Land fronting, Turnbull Road, Fradley, Lichfield

**Application by Massey Limited for the variation of Condition 2 of planning permission
REF: 18/O1693/FUL**

This Application is for variation of Condition 2 of planning permission 18/O169/FUL, 28th October 2020. That planning permission is for the erection of 8no. dwellings and associated works.

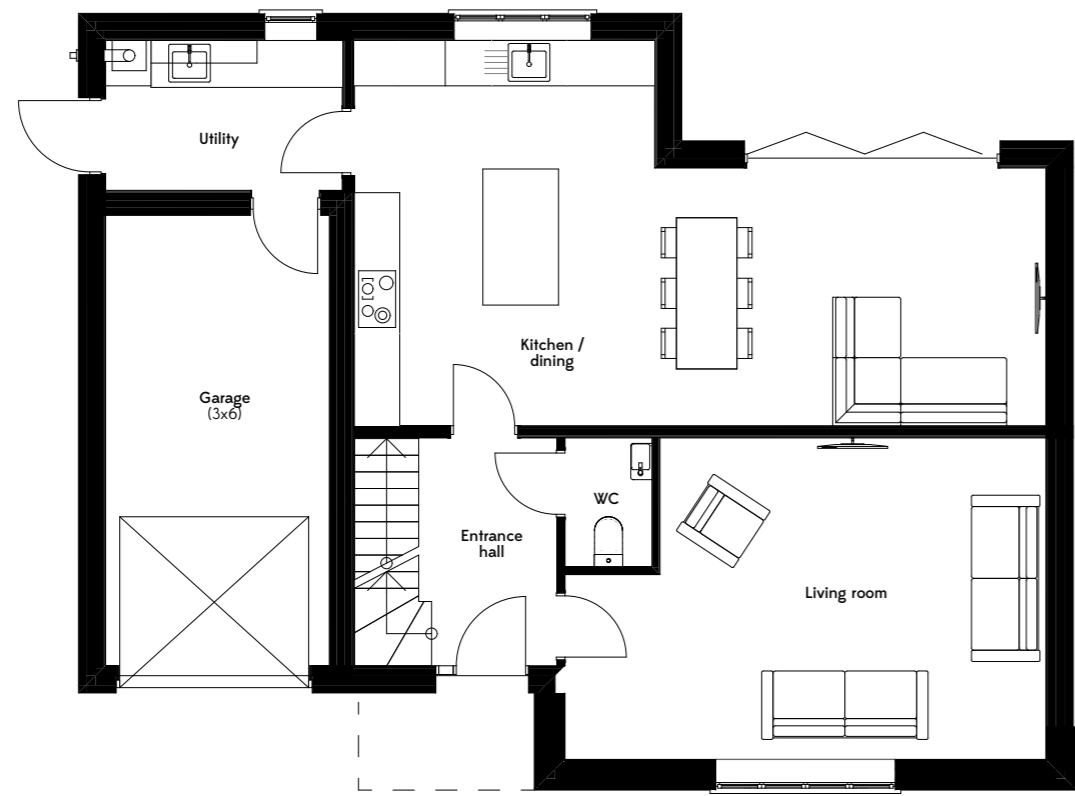
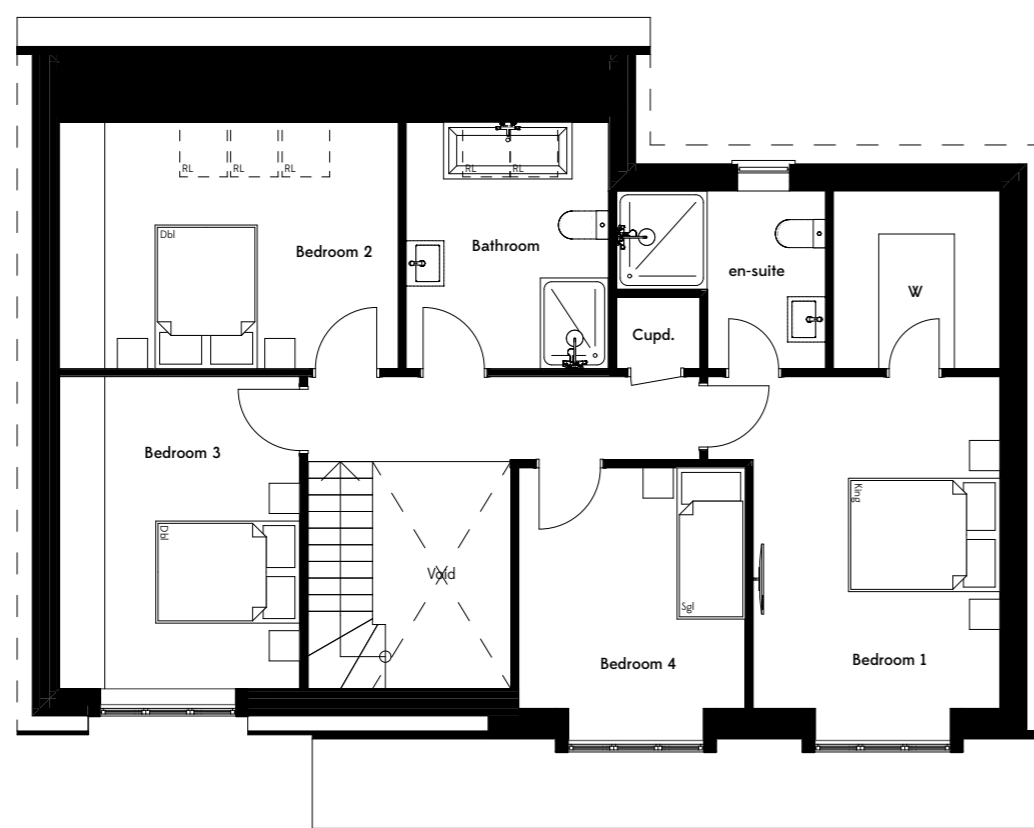
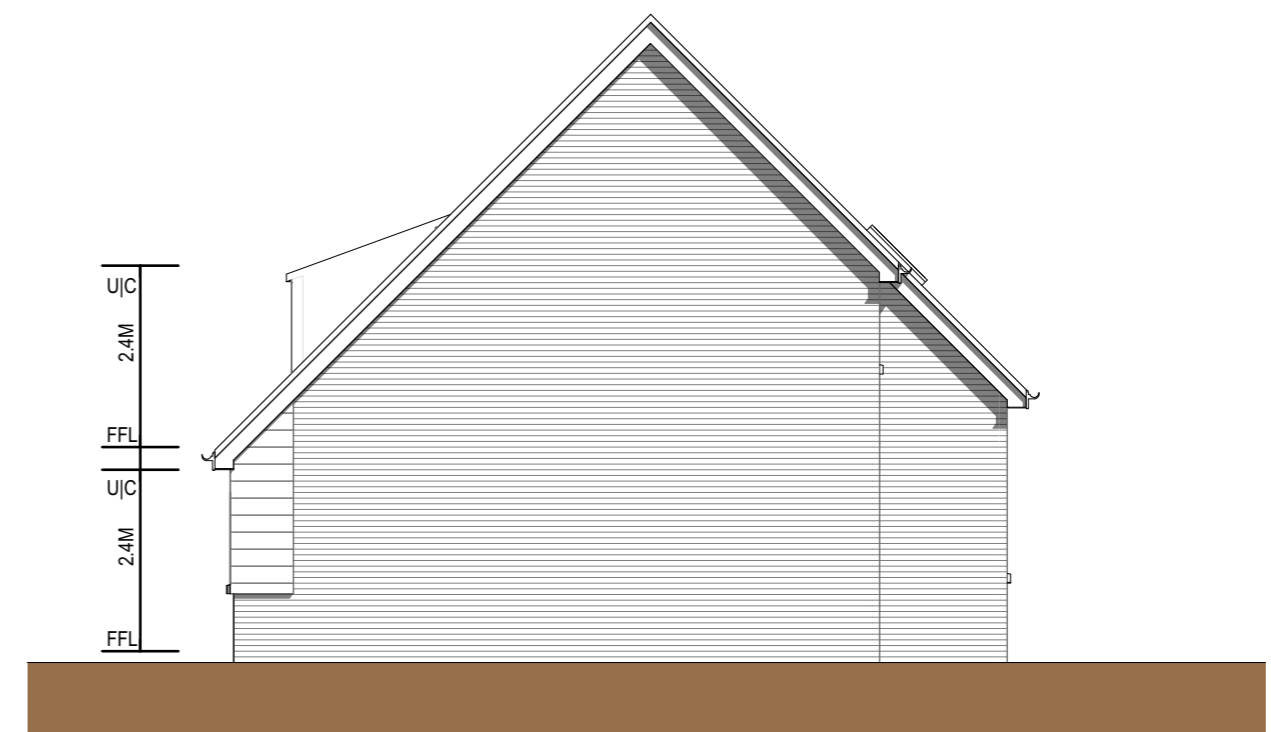
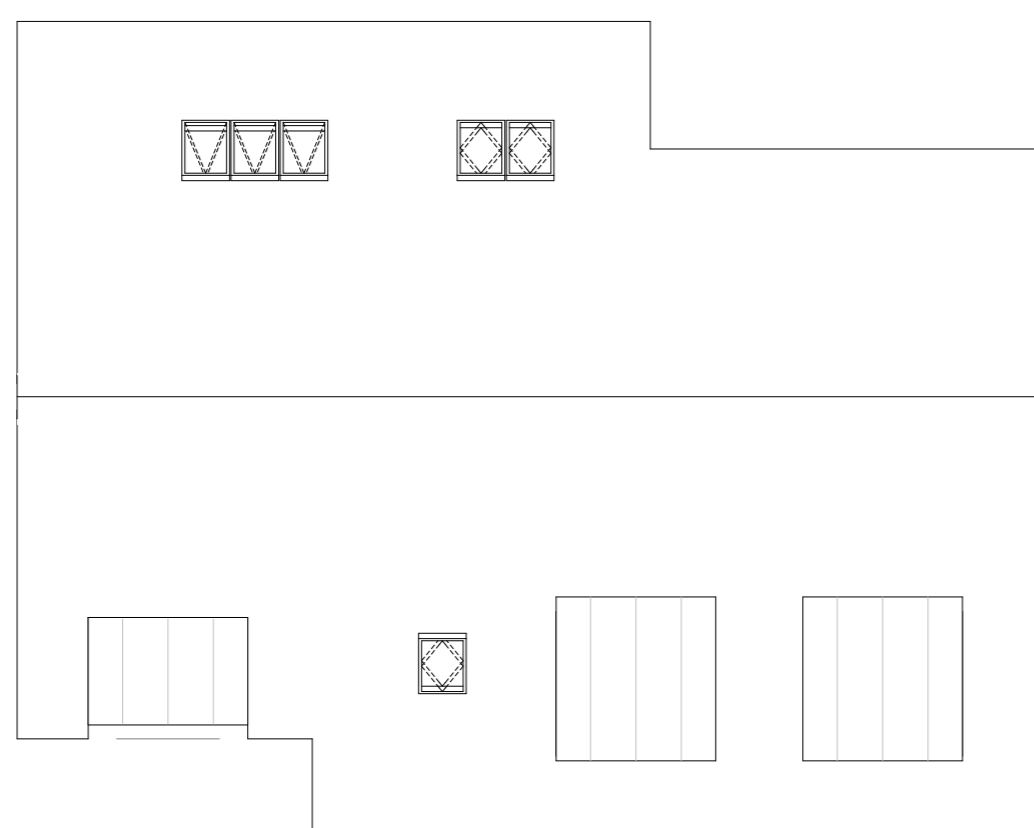
House Type 2

- GIA reduced from 177.4sqm to 171sqm.
- Double height glazed entrance omitted.
- Covered porch with timber structure added.
- Dormer windows added, in keeping with the design of House Type 1.
- Timber cladding added to front of house, in keeping with the design of House Type 1.
- Internal layout revised.

PLANNING | HOUSE TYPE 6

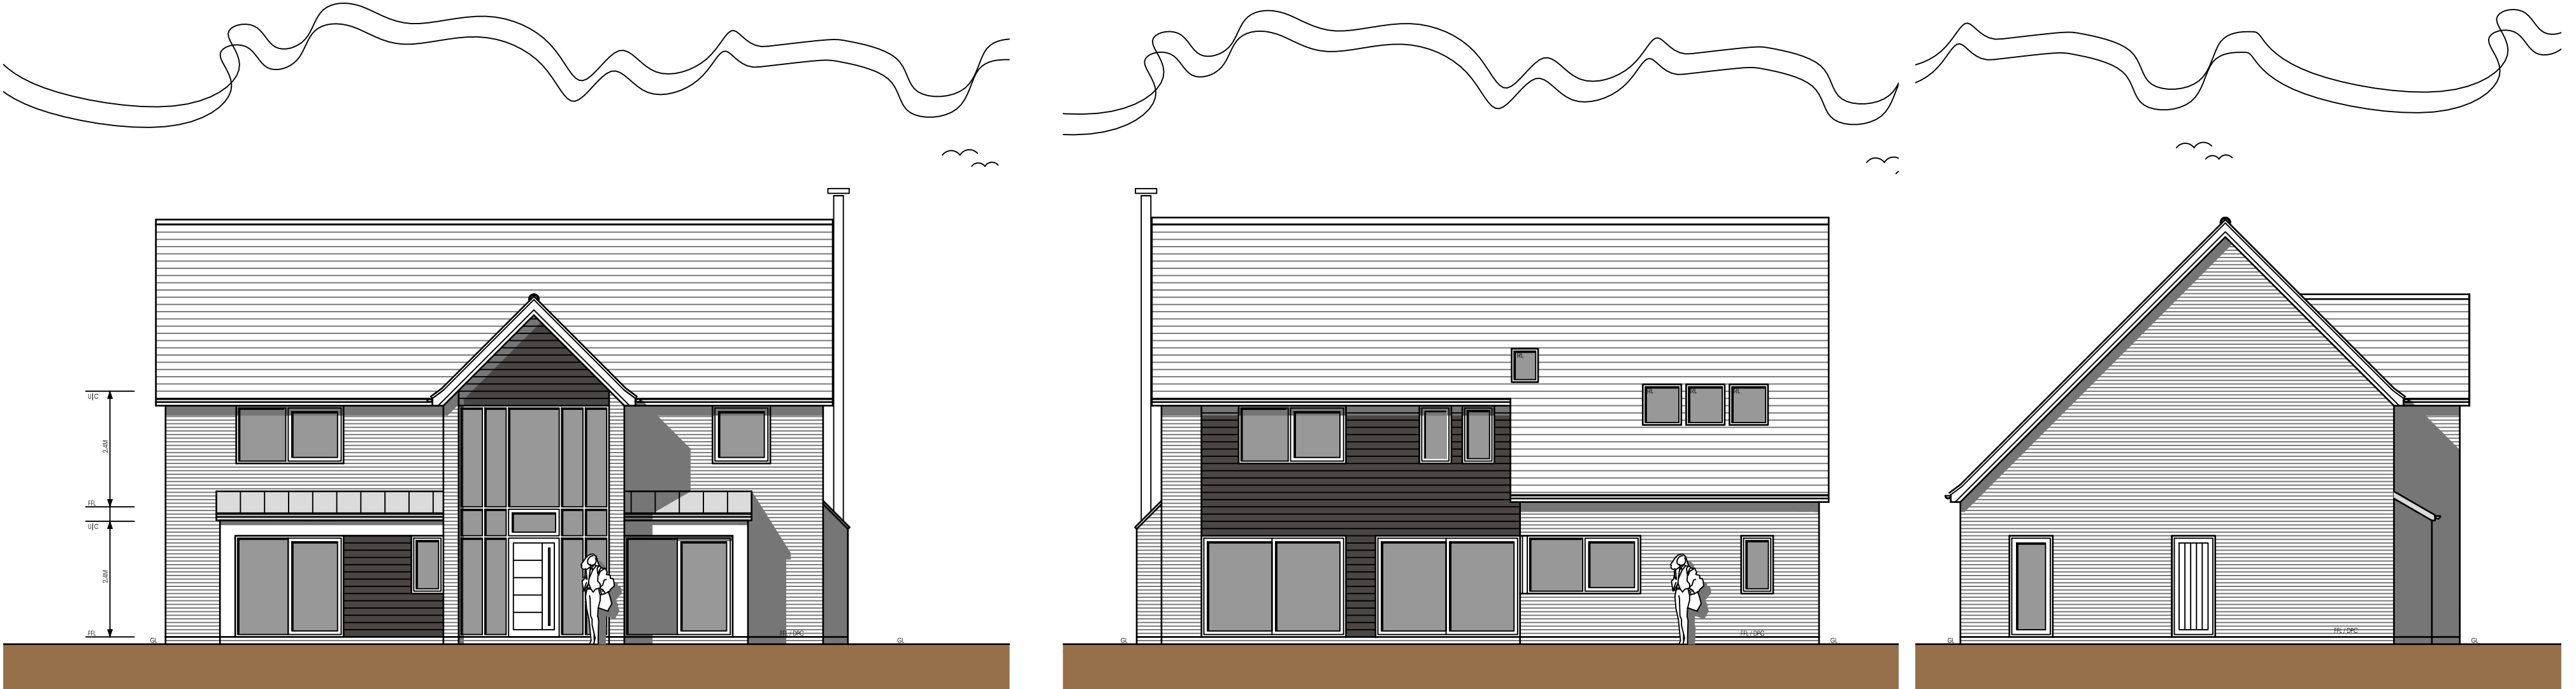
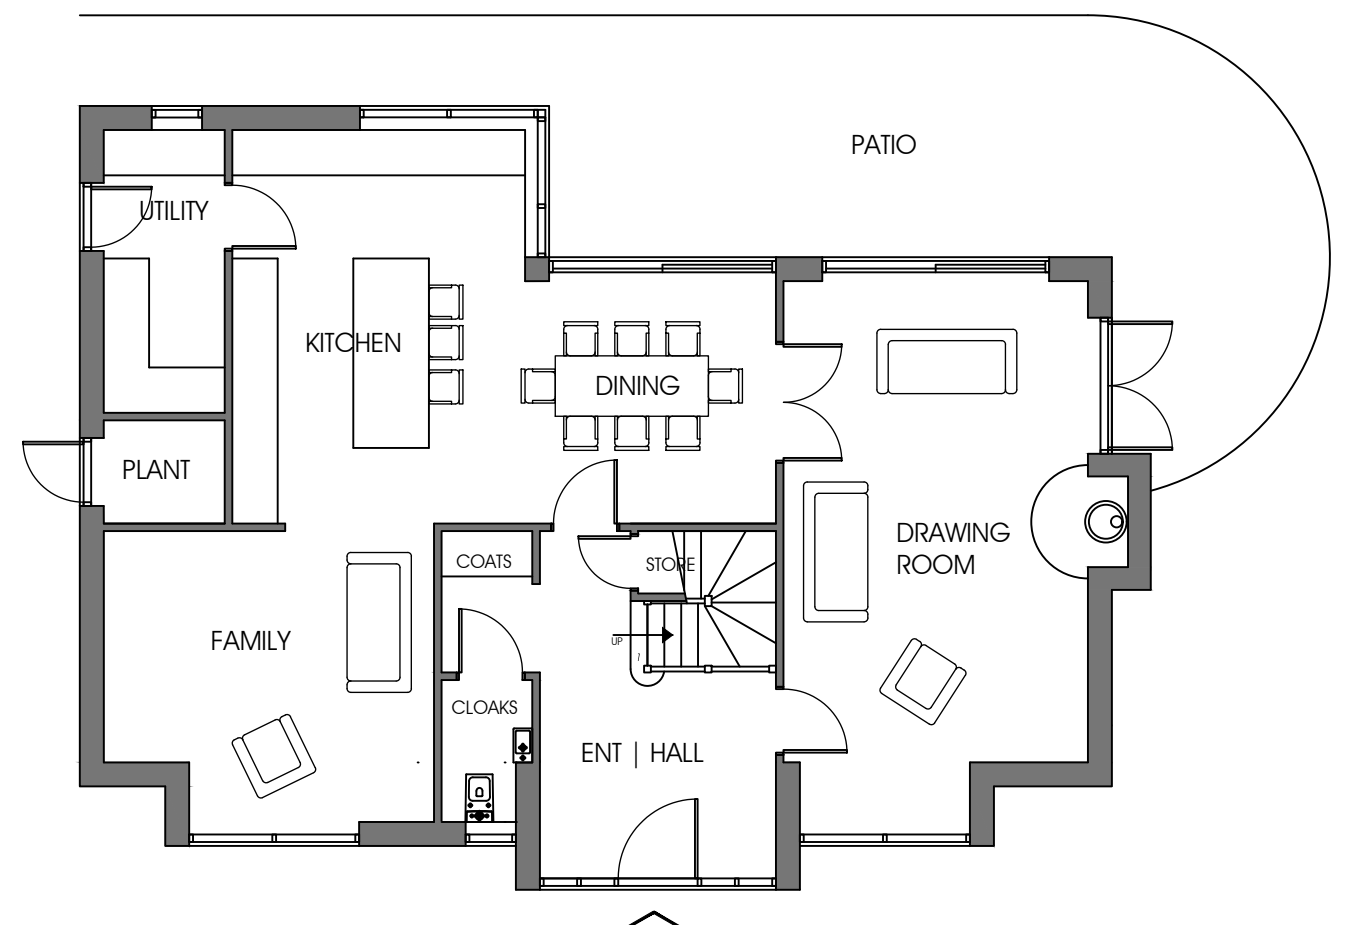
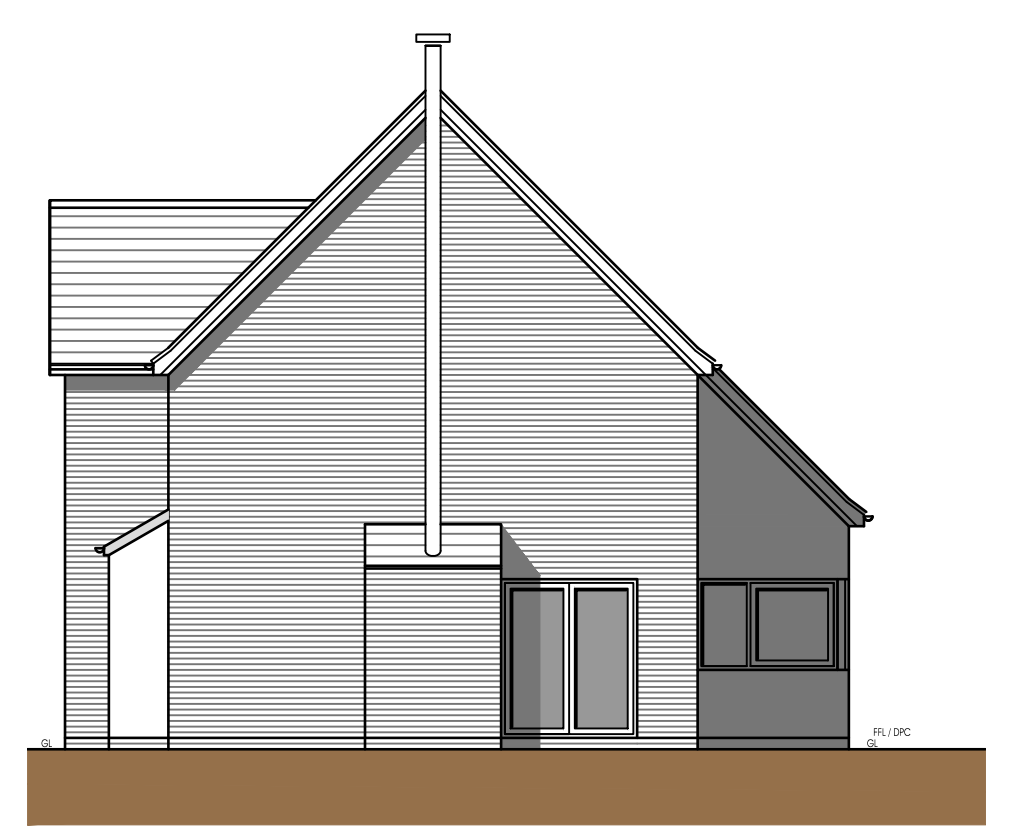
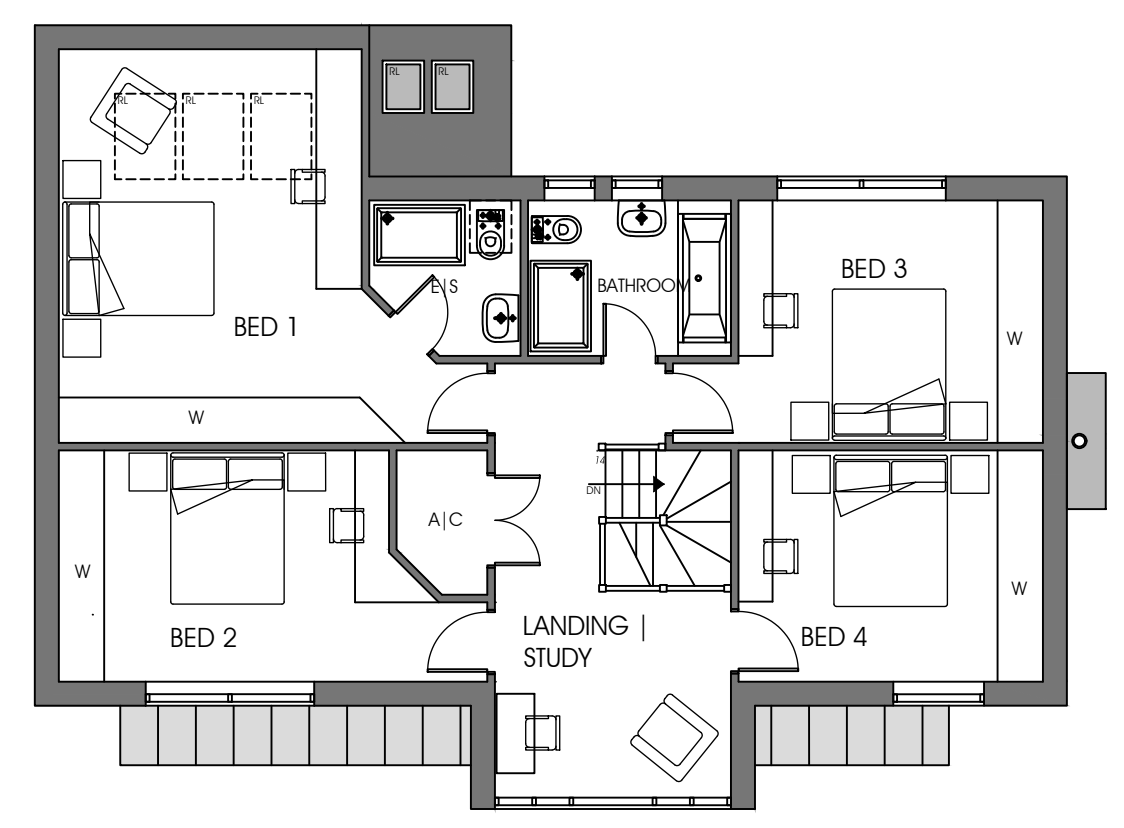
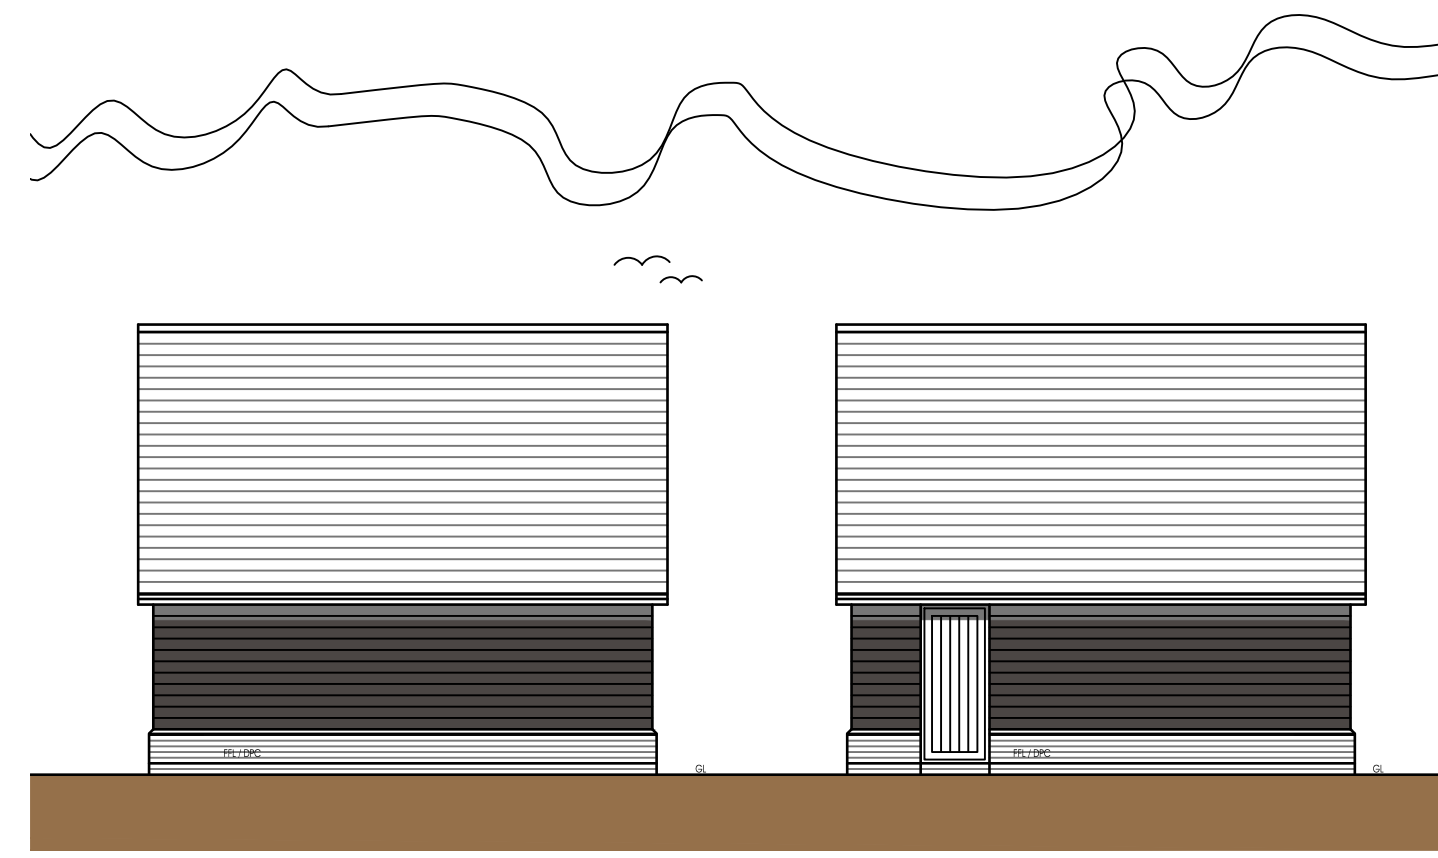
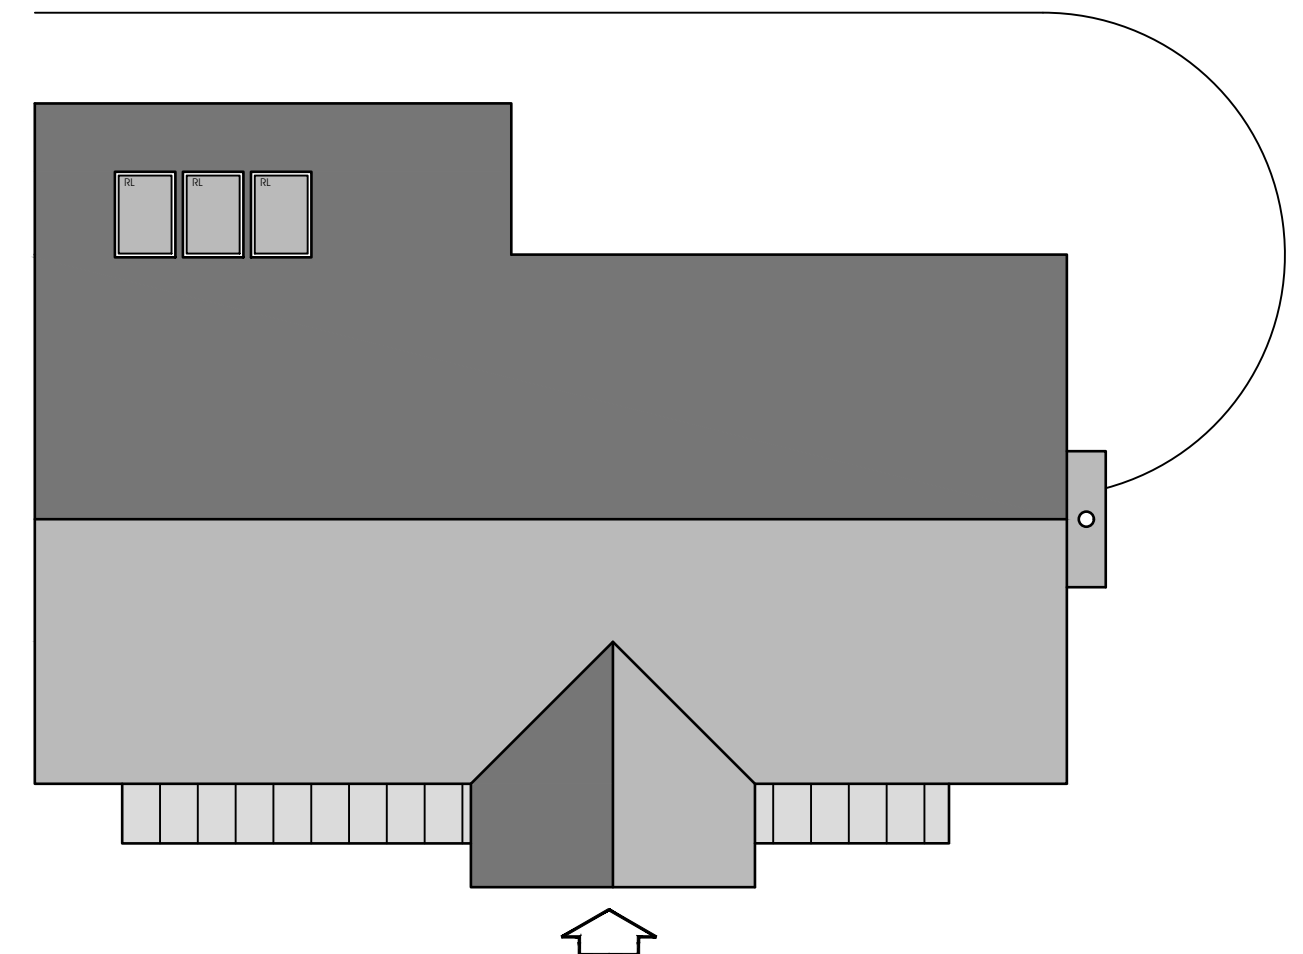
Proposed minor alterations to external materials, namely the roof covering and window frames are outlined below.

Roof covering - Marley Ferndale tiles do not exist. Marley Edgemere tiles are a slate-style tile, in keeping with the consented design.

Windows and doors - Flush casement anthracite grey window frames proposed in lieu of PPC black frames.
